Application No: Y/53/22/DOC
Registered: 29th April 2022
Site Address: Land at Stakers Farm North End Road Yapton
Description of Works: Approval of details reserved by condition imposed under Y/44/17/OUT relating to condition 17-as built drawings of implemented scheme.

Following your comments on my email the other day, please find below the response for: Y_53_22_DOC

The construction does not appear to have been carried out in accordance with the design, in addition there are still elements of the construction which are wholly reliant on the contractor's information rather than an independent verifier. As a result, **we would not recommend Discharge of Conditions** until the following information has been provided and following points have been addressed and approved in full.

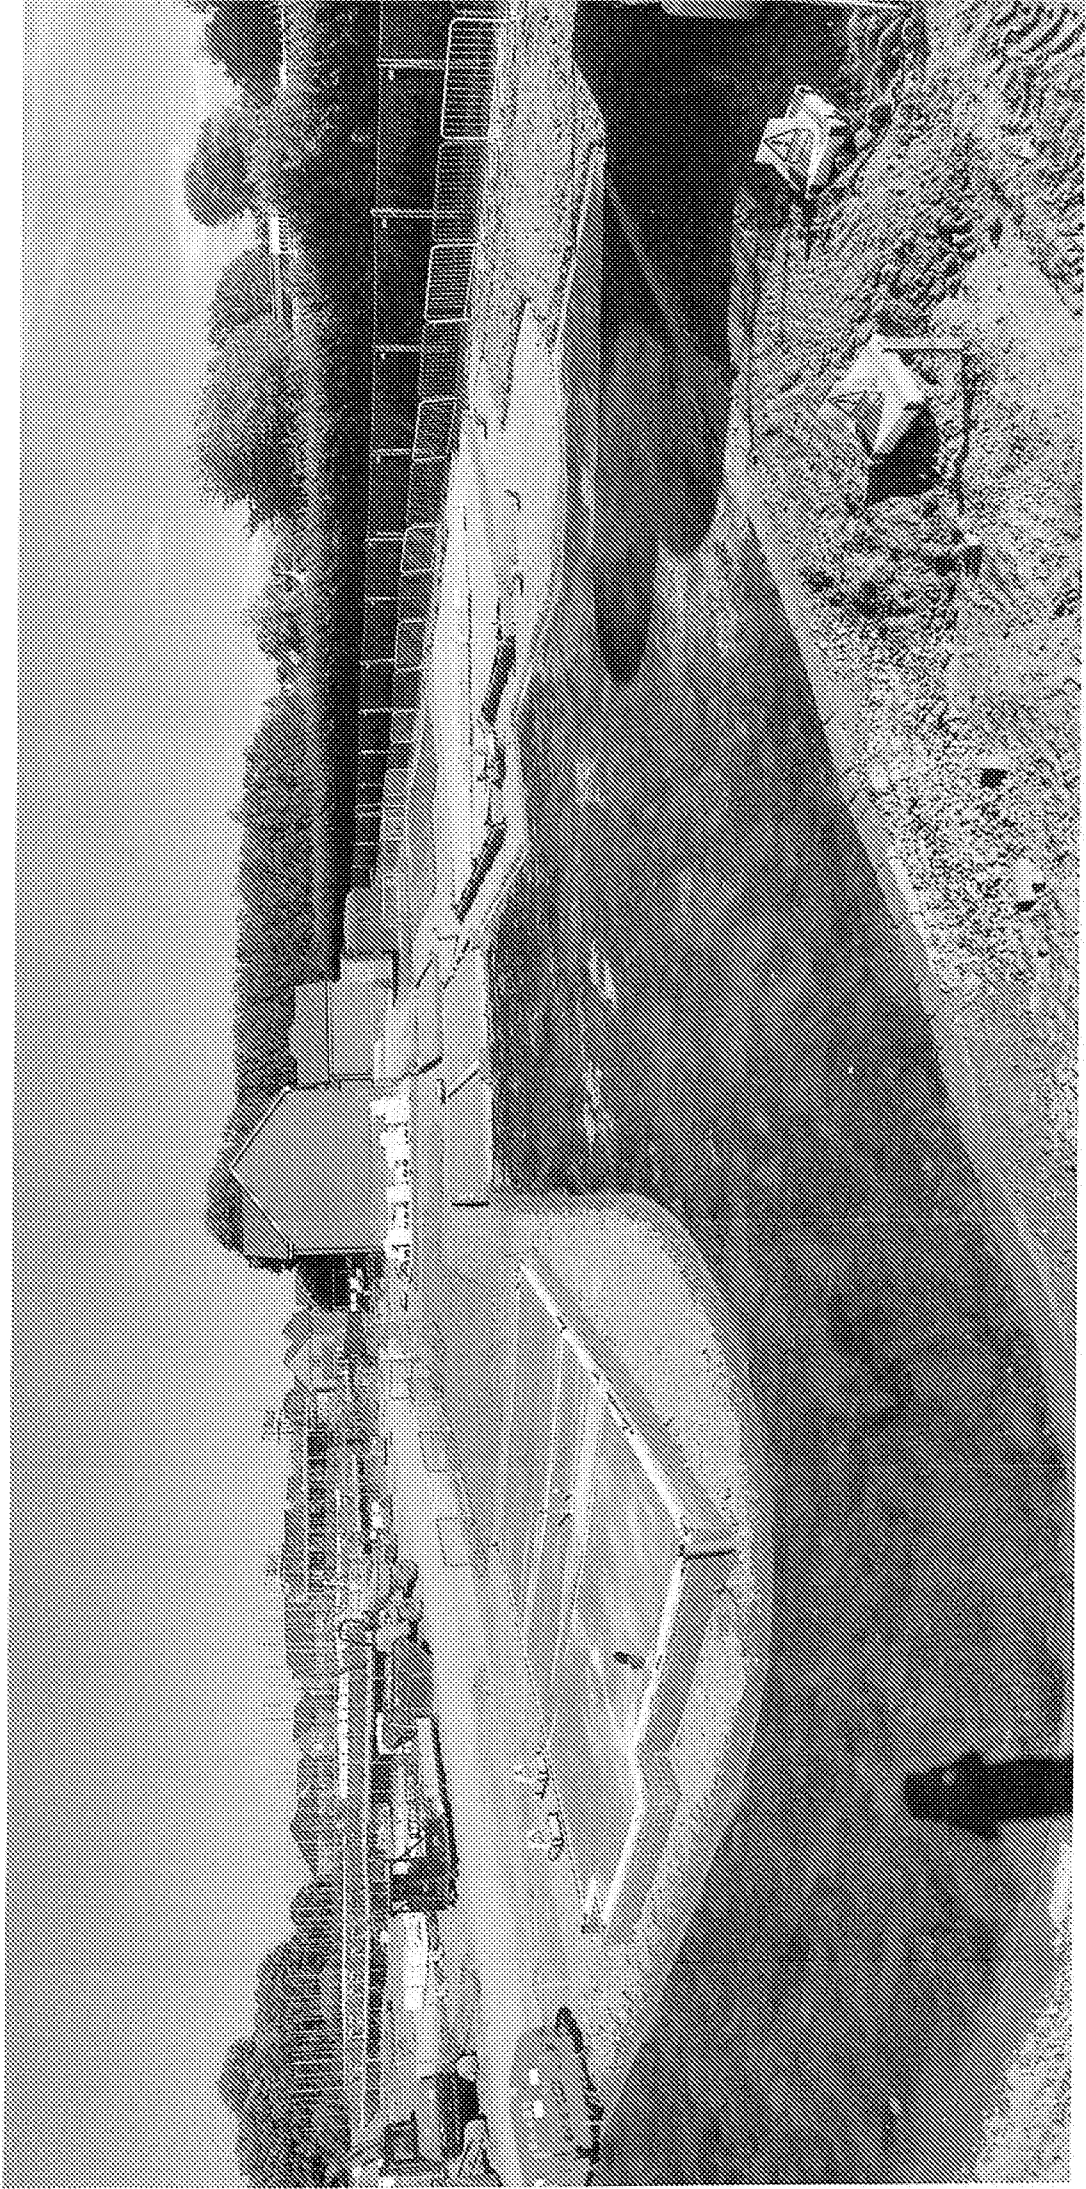
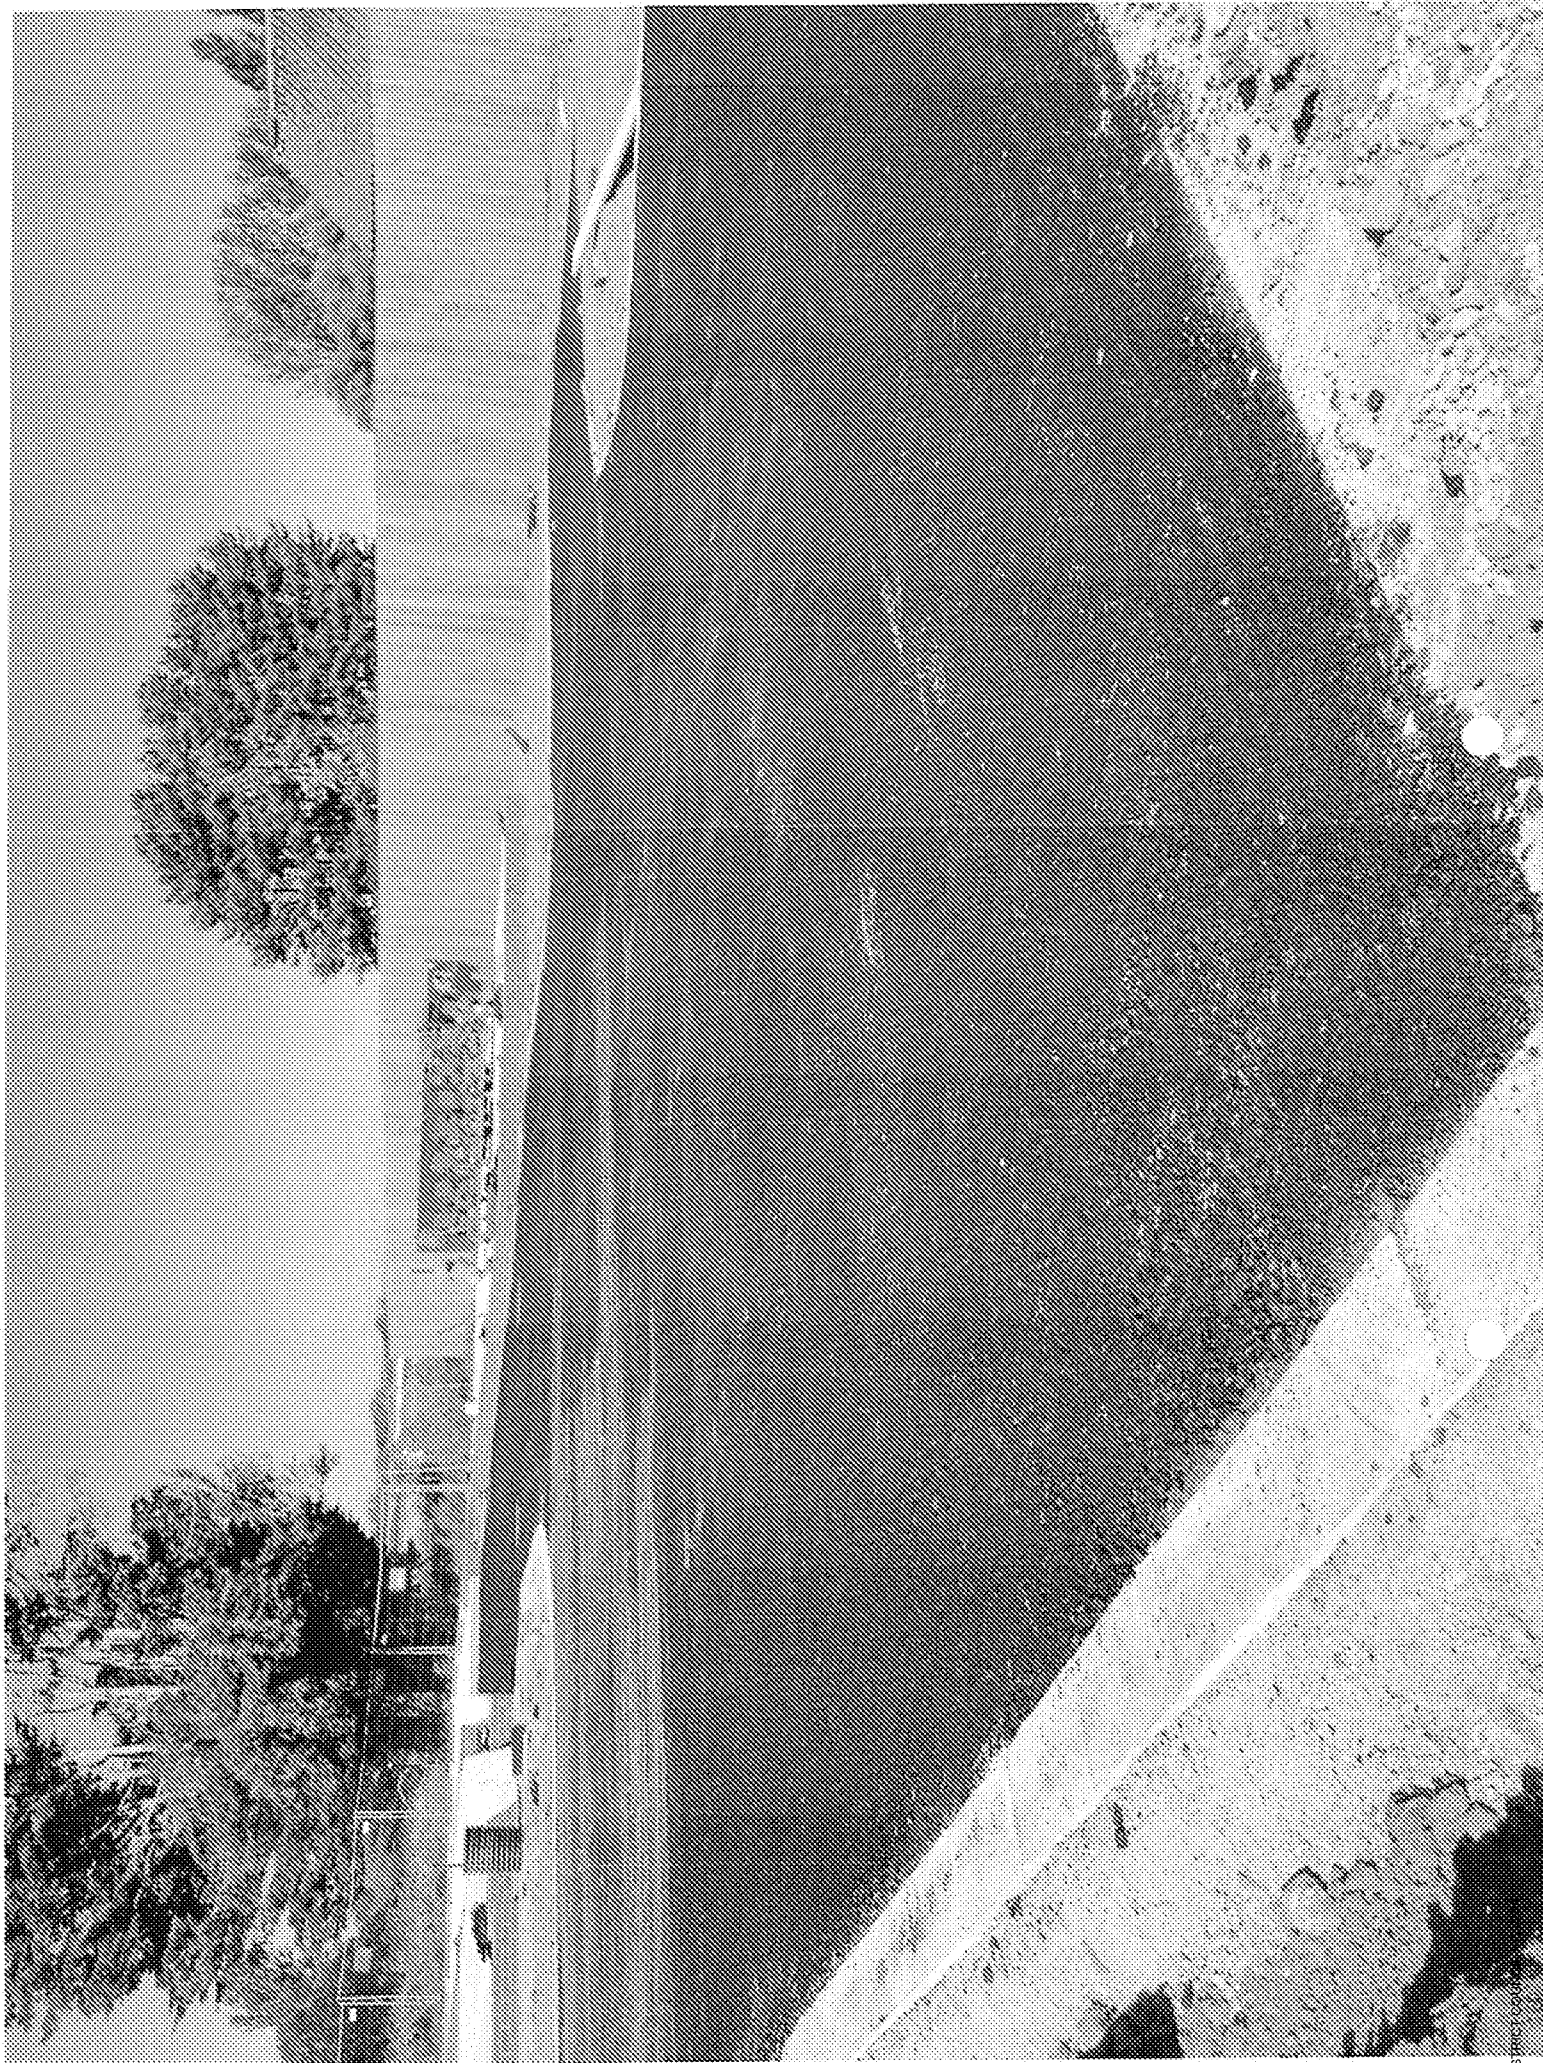
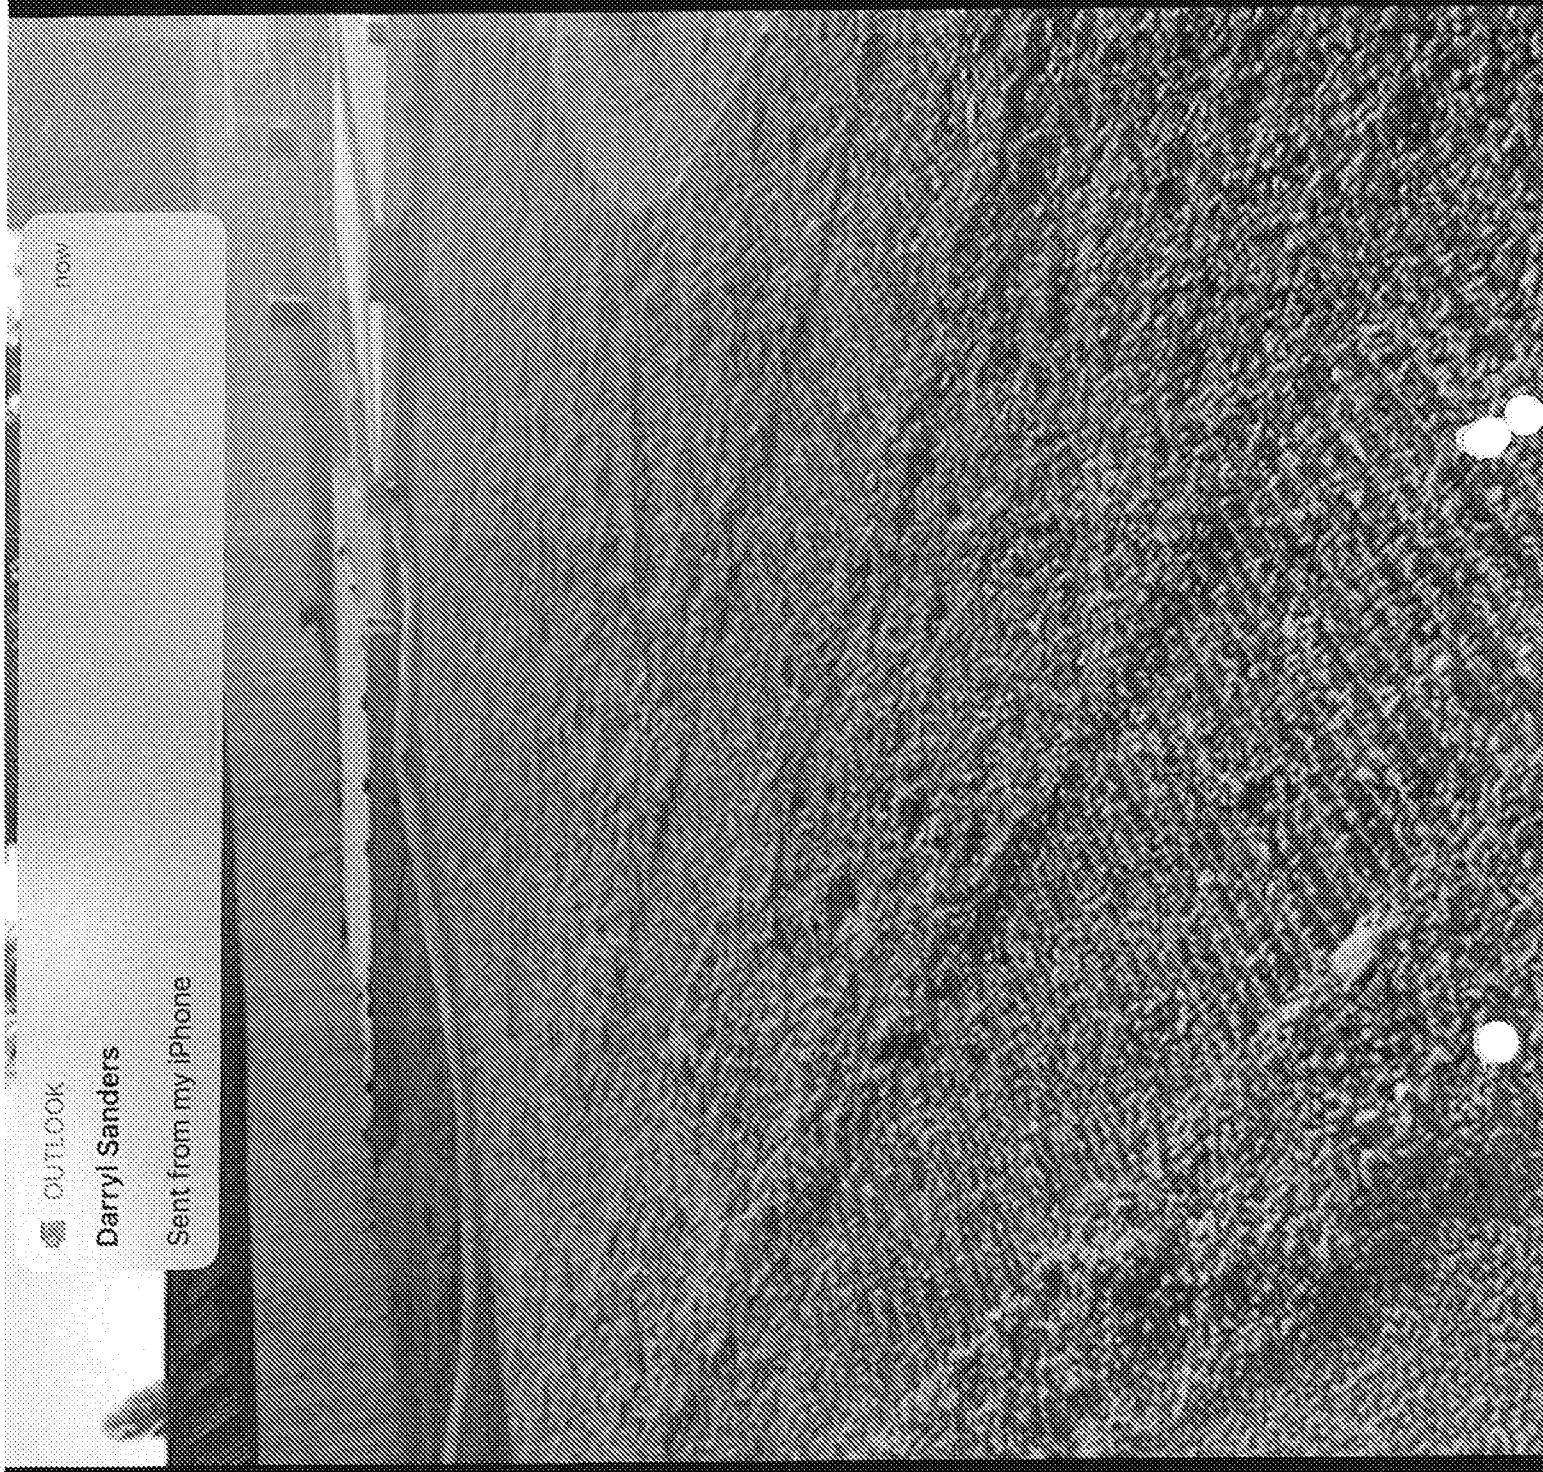
- 3) Some of the installation seen in photographs provided as part of the application does not appear to match the design drawings, and in some cases contains clear issues that need remediating or checking (as part of point 2). These include but are not limited to:

- Checking the membrane and gravel surround to some of the soakaways / infiltration blankets to ensure there is a membrane between the crates and gravel surround. This appears not to be the case in one of the photographs although it is unclear if this was simply a photograph showing the system prior to or post of the membrane being laid. Checking this was installed correctly and as designed will be essential.

- Checking and remediation of the poorly constructed sediment traps (assuming they are installed as photographed). The sediment traps should be installed as per the submitted drawings. These photographs show several defects in construction including square cut outs used to house round pipes, cracked rims and

plastic, the use of unapproved materials within their construction, rubble filling the base (which visually cannot be confirmed to have been lined) and concrete which appears to have been used as a sealant and is partially blocking one pipe outlet. None of this appears on any of the approved drawings.

- A proposal for remediating these issues should be submitted.
- 4) The letter submitted detailing all of the drawings refers to YAP-180-31 REV C4 however, the submitted planning drawing is Revision C5. The applicant will need to confirm which drawing the contractor was working off and confirm that the scheme was not constructed to an earlier design.
- 5) We also acknowledge significant differences in the levels for the base of the permeable surfacing, and appreciate the revised calculations showing that this will only result in minor flooding in one area of the site. This is noted to occur but is not significant enough to warrant remediation as the volumes are small and flooding only occurs infrequently (based on the model results).
